23rd July 2026

Application No: FG/47/26/PD
Site Address: The Haystack Sea Lane Ferring BN12 5EP
Description of works: Prior approval under Schedule 2, Part 1, Class AA for the removal of existing roof, construction of new walls above existing walls to form new first floor walls and erection of new roof with a maximum height of 10.35m.

SECOND FLOOR PLAN | PROPOSED

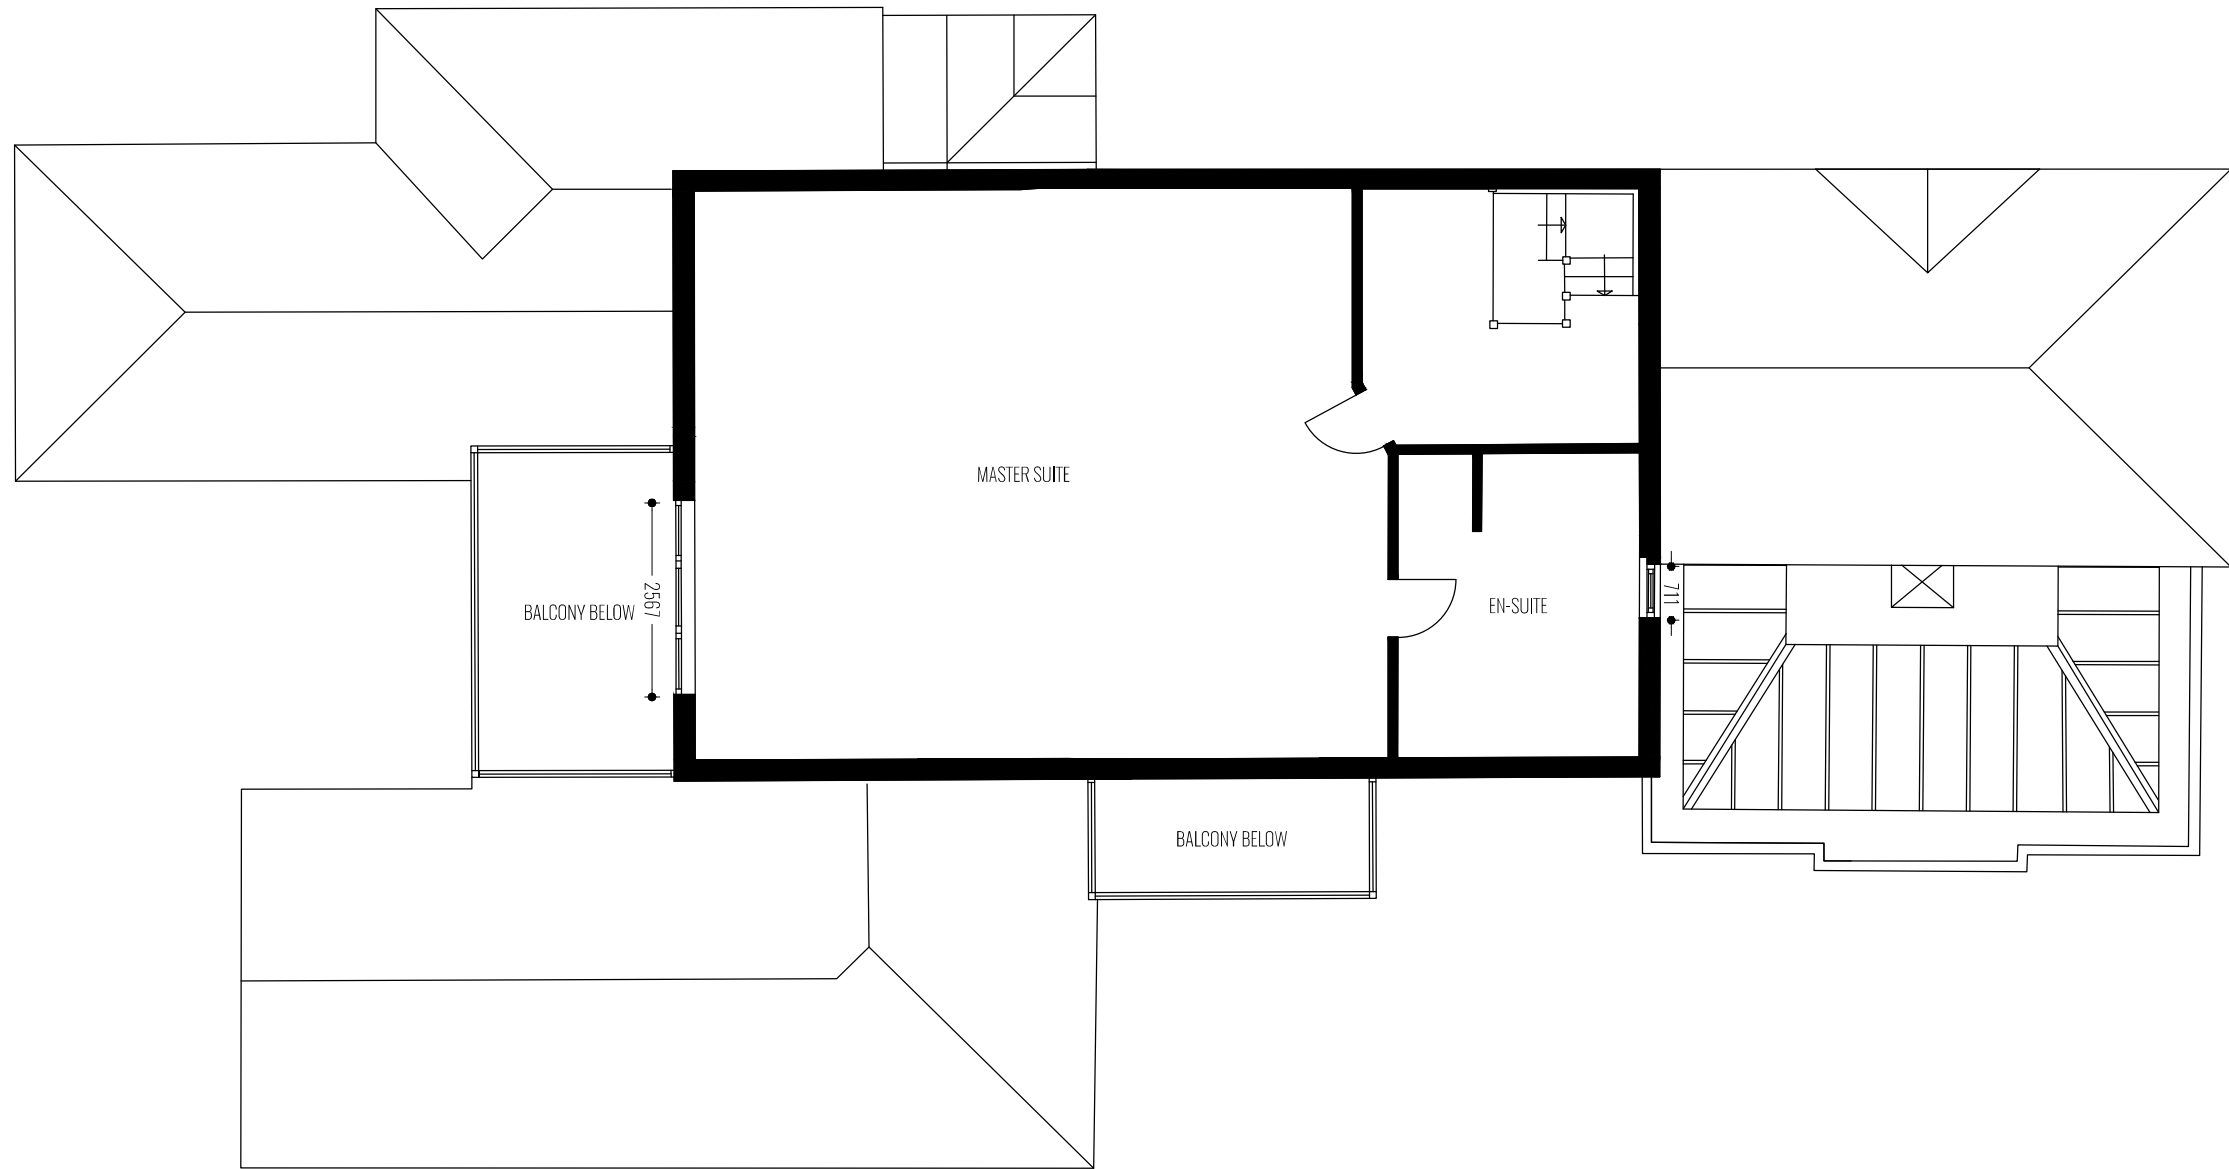
The proposal seeks to develop the existing traditional styled dwelling into a three-storey building (plus roof space). Windows at the third storey level look out to the east and west. The impact of proposed third level from the south presents a large wall above the tree line and a direct, dominant visual impairment to the southern Gap and the views northwards to Highdown Hill from public footpaths and the greensward of the popular beach area. Such a large-scale feature in the rural setting of the southern Gap is out of keeping and conflicts with the designation of the Gap.

This proposal attempts to circumvent the planning objections which resulted in the refusal of previous application FG/22/26/PL to develop a three-storey building on this site. This does not, and cannot, address the fundamental issues of the detrimental visual impact of a three-storey building within the open landscape setting and the undeveloped character of this important settlement gap and the views to Highdown Hill to the north.
